Job No. 198337

December 5, 2025

Re: Response to Review Comments
Antelope Ridge at Bull Hill, Phase 1
Bradley Rd
El Paso County, Colorado

The purpose of this letter is to provide RMG's response to the comments provided by El Paso County (EPC) and CGS. For clarity and ease of review we have included a “snippet” of the comments below, each followed by our response to that comment.

SHEET No. FIG-2

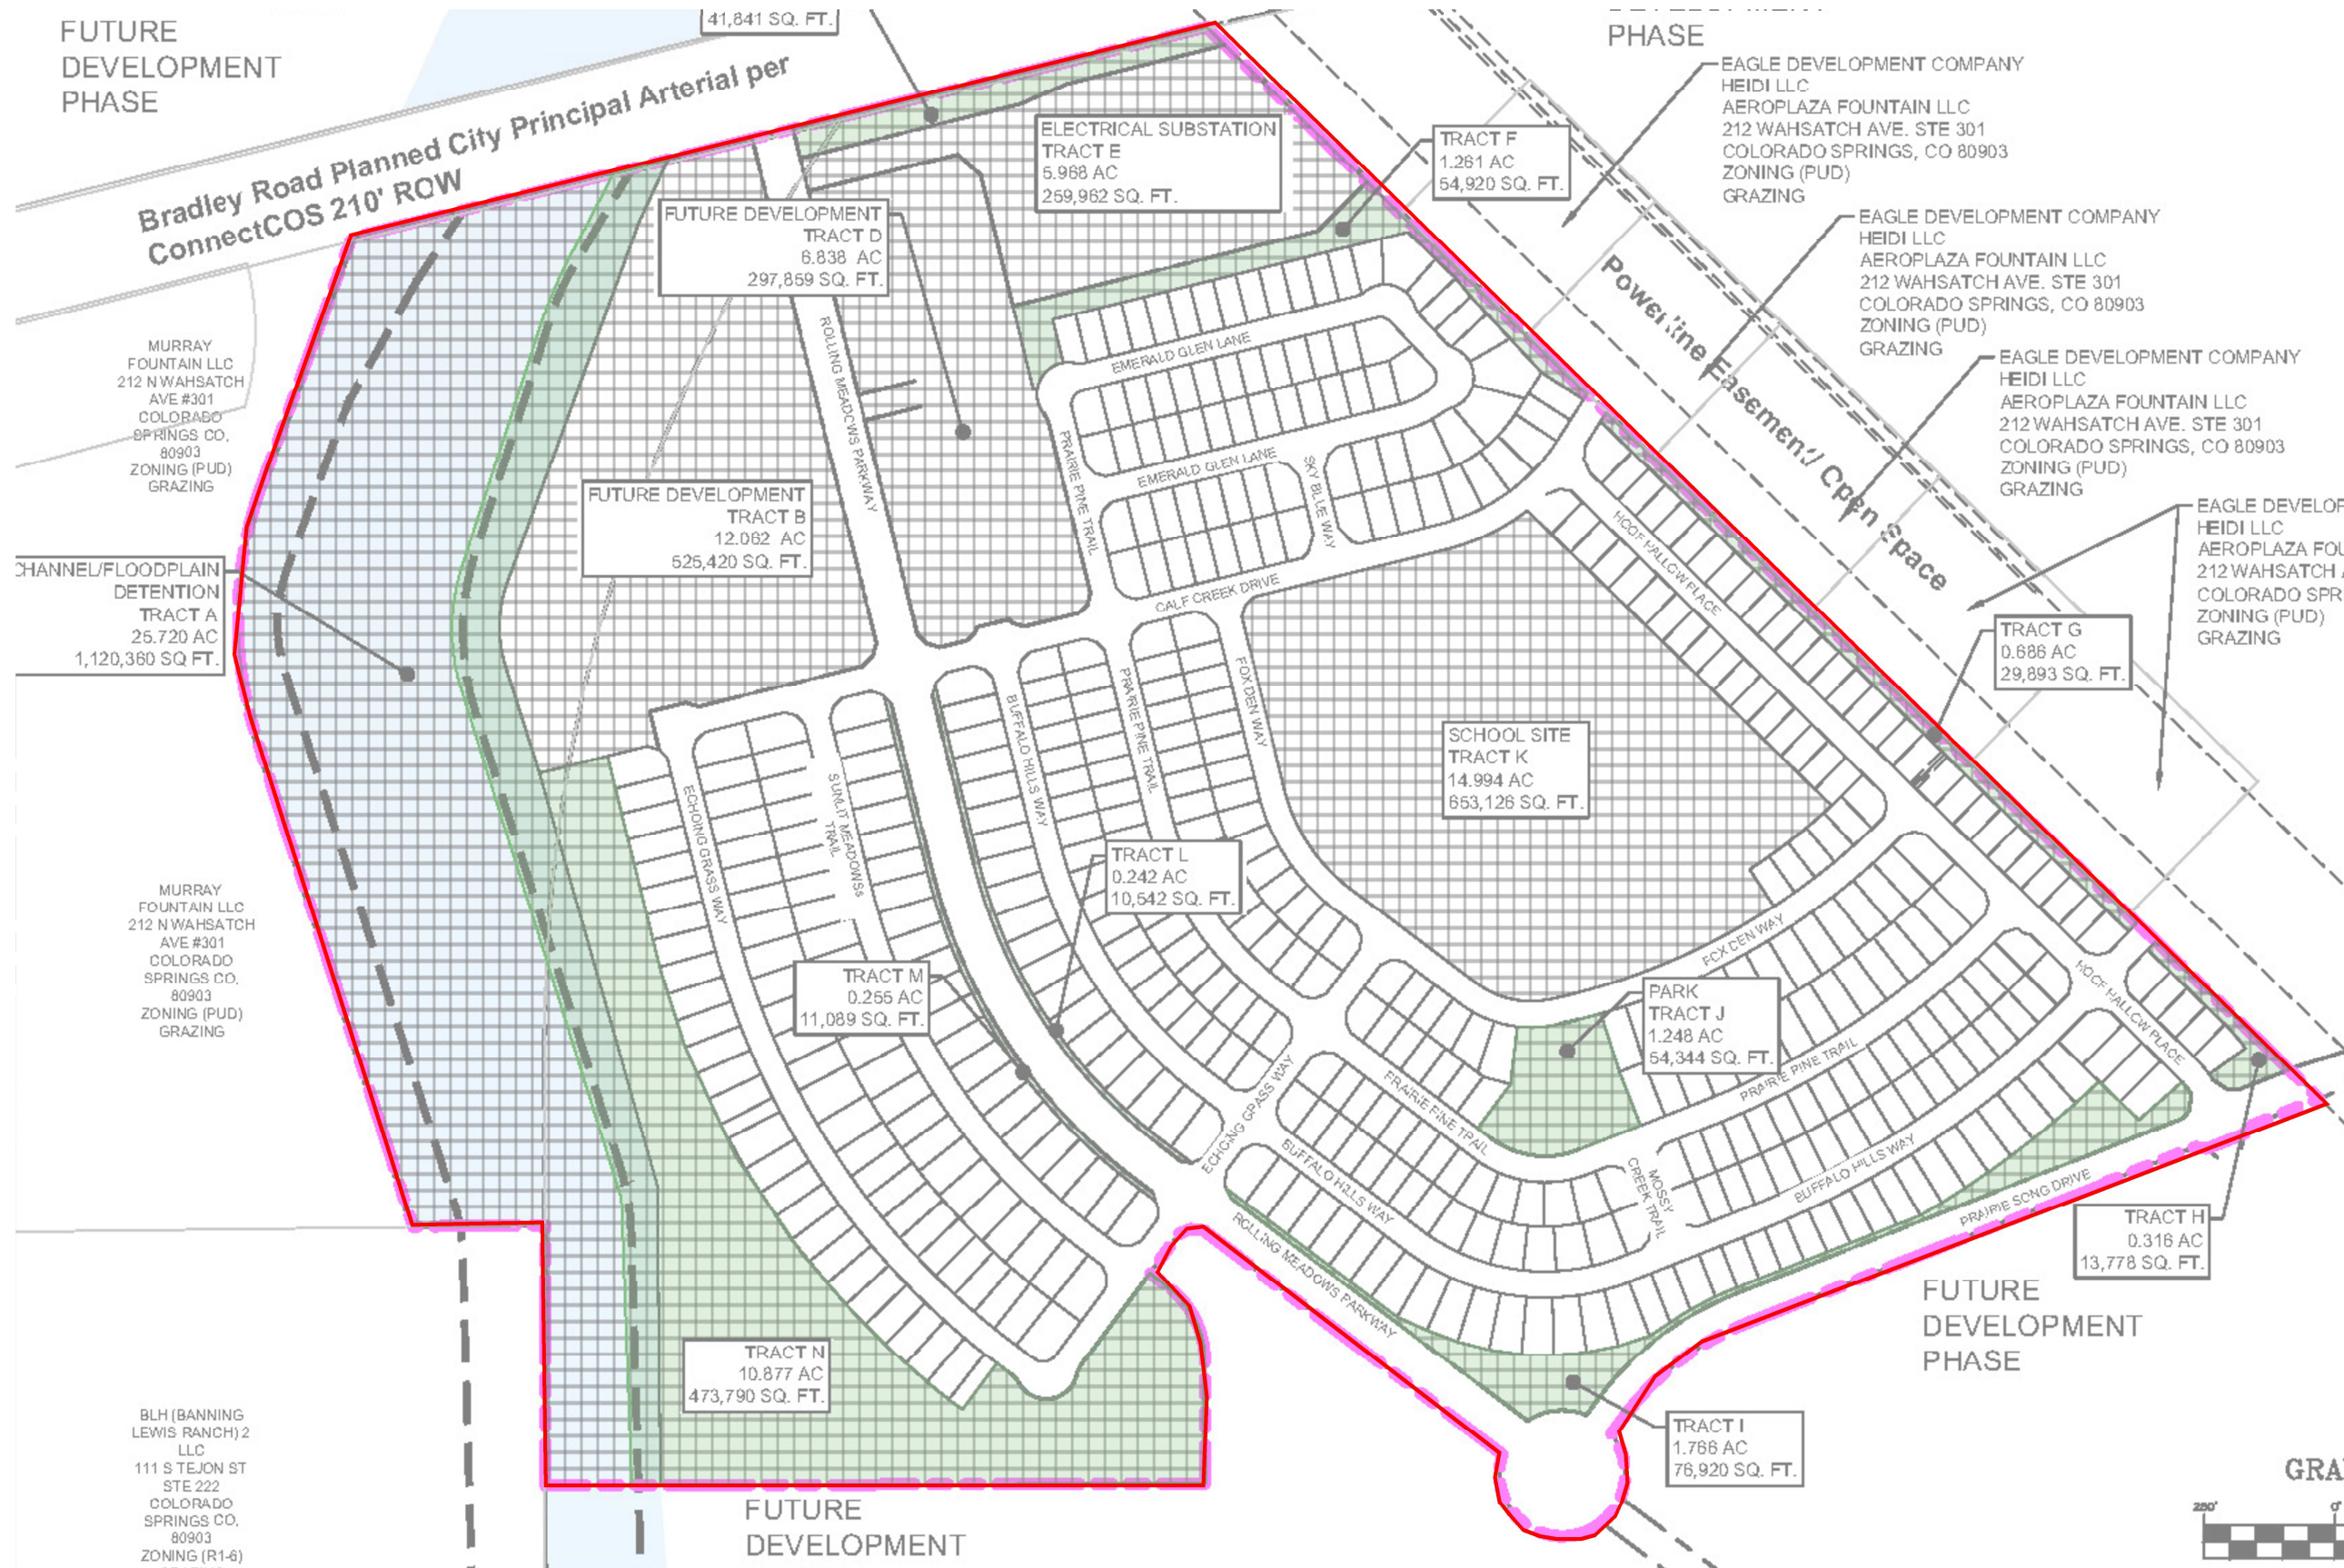
PHASE 1 AND 10
 Please provide a clear figure showing all three test borings. If TB-2 is near the proposed pond, that could indicate potential for groundwater flow into the pond which would require mitigation. It is hard to tell without a figure that is clear where the borings are and the potential for this impact.
 It is not mentioned in the 3 test borings performed for this report, at the time of

The amended report dated December 5, 2025 has been updated to reflect the additional requests. As for the comment on the location of TB-2, it is not located within a proposed pond per the Planned Unit Development provided by Matrix, last dated August 2025. TB-2 was located near

Jimmy Camp Creek within the floodplain in Tract B designated for future development. A clearer Test Boring Location Plan, Figure 2 is included in the amended report.
